Please ask for: Ms Iqraa Malik
Email: iqraa.malik@terraquest.co.uk
Telephone: 01212341390
Our Ref: BR/294/20/HH
Your Ref:
Date: 8th December 2020

Application for Planning Permission for Works or Extension to a Dwelling

Development: Small side extension to accommodate a ground floor shower room
Location: 33 Marshall Avenue Bognor Regis PO21 2TL

Drawing: Proposed Block Plan

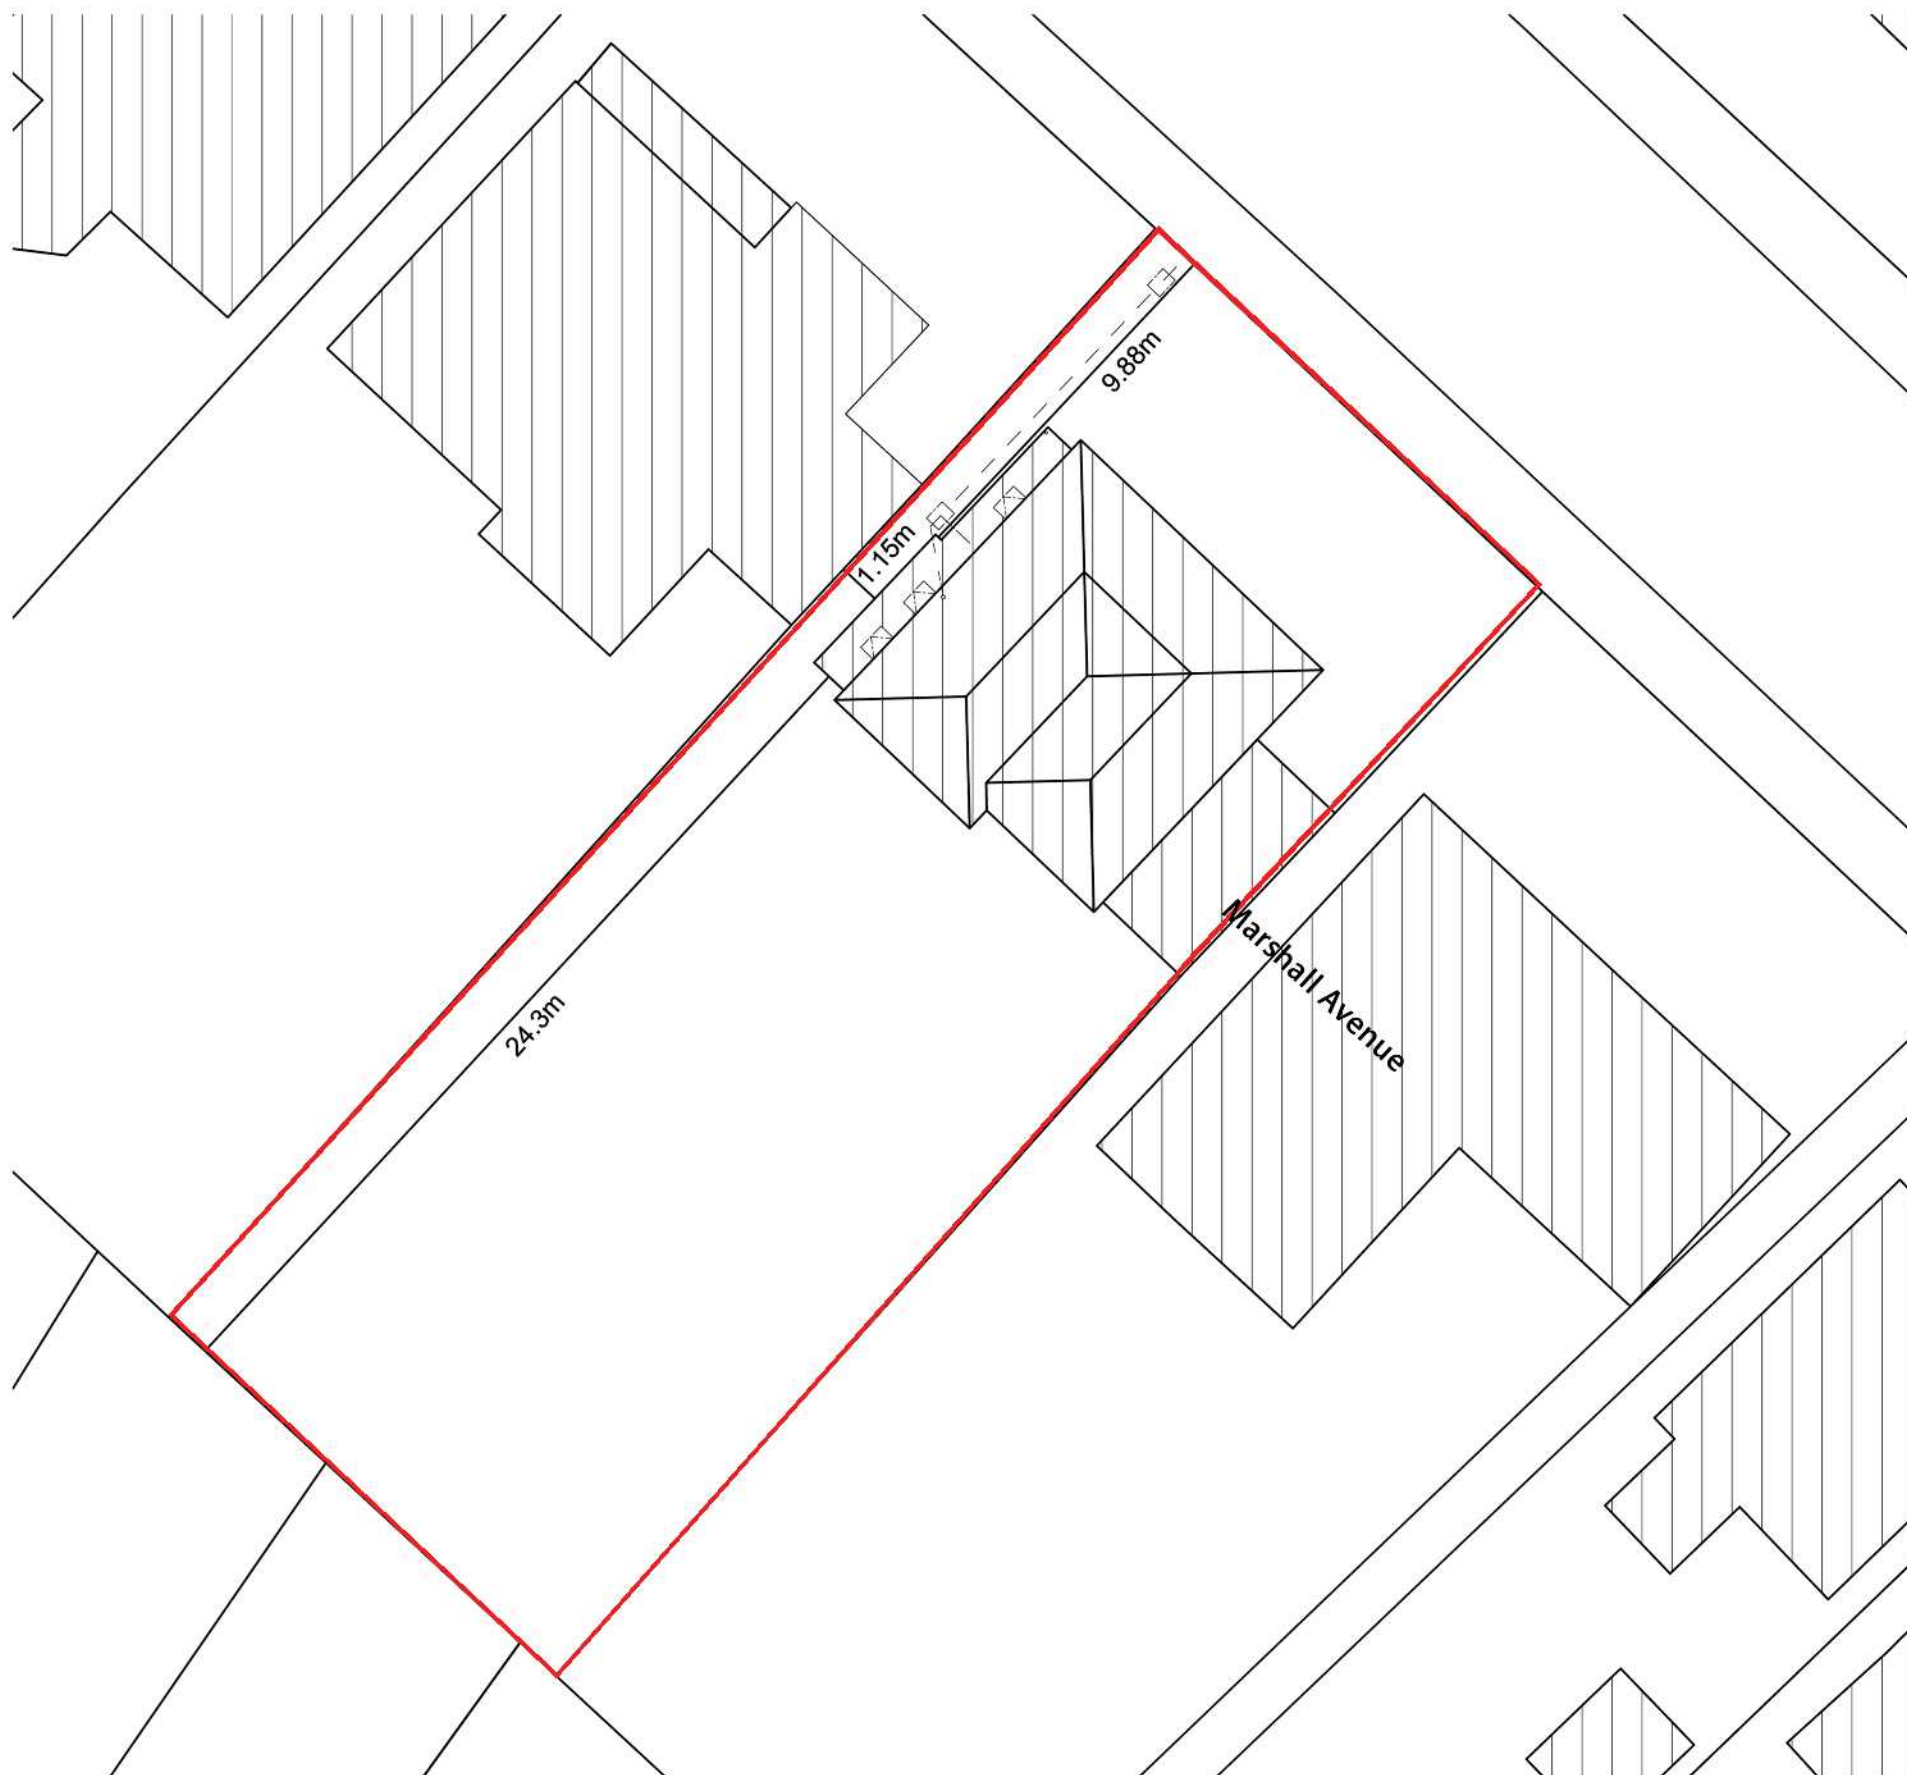
Block Plan

You are required to have dimensions from the proposed extension(s) to all site boundaries. Please amend.
